Planning Services Sign Permit Review Form

Ground Sign: SIGN1811-0004

Date of Submittal	Application Number	Applicant	Landowner
11/19/18	SIGN1811-0004	Sign Clinic	Ralph Huff Holdings LLC
Contact Person	Contact Number	Sign Location	PIN Number
Jeremy Norris	704-664-4389	1608 NC 24-87	9584-87-9951

**PROPOSED SIGNAGE
NEW SIGN WITH NEW FOUNDATION
ENGINEERING REQUIRED**

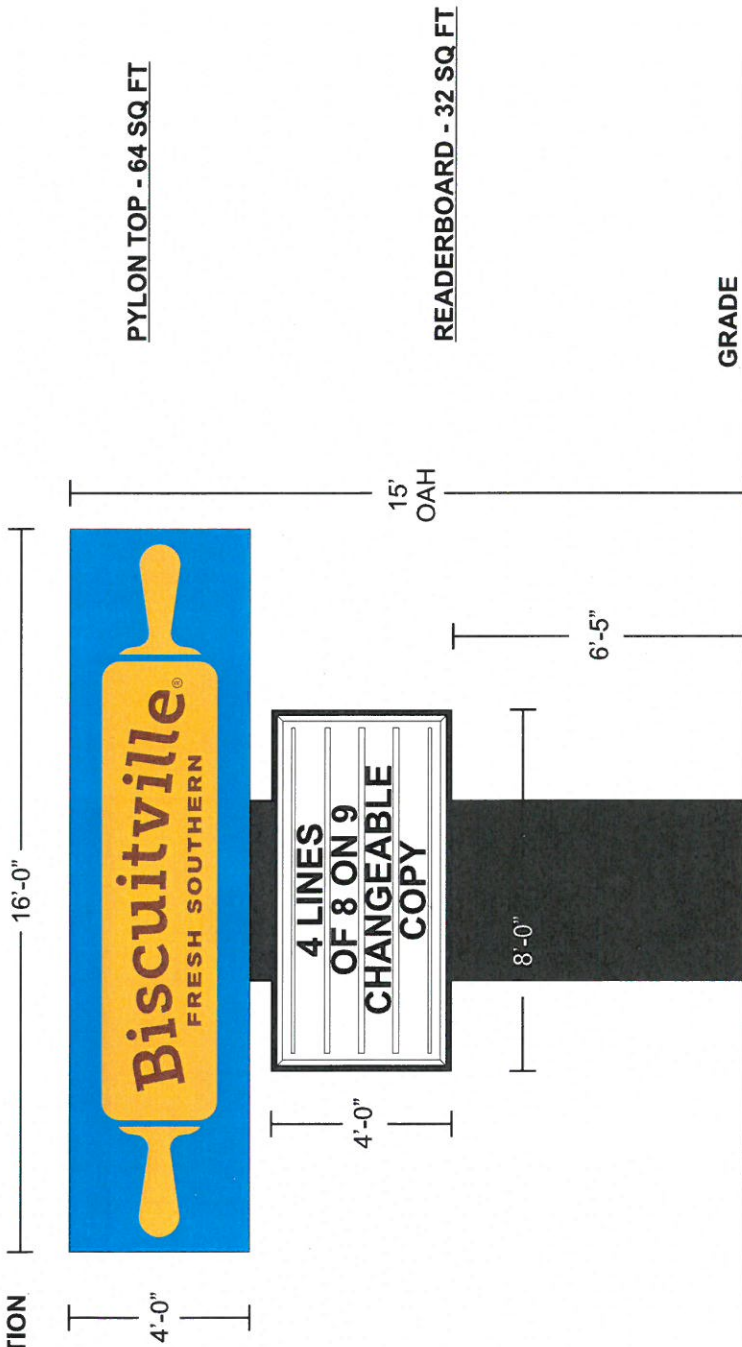
- ✓ what is width of pole encasement? 4 feet wide
- material? Aluminum
- ✓ Need site plan depicting that sign will be at least 10' from R/W.
- Proposed to be 16 feet
- ✓ ~~Comm Land Use App~~

$$\begin{aligned} \text{A. } \bullet \text{ Sign (Top)} &= 16' \times 4' \\ &= 64 \text{ sq. ft} \end{aligned}$$

$$\begin{aligned} \bullet \text{ Changeable copy portion} &= 4' \times 8' \\ &= 32 \text{ sq. ft.} \end{aligned}$$

$$\text{B. Total Sign Sq. ft} = 96 \text{ sq ft total} = \text{ok}$$

$$\text{C. Changeable Copy is } 33\% \text{ of total sign area} = \text{ok}$$
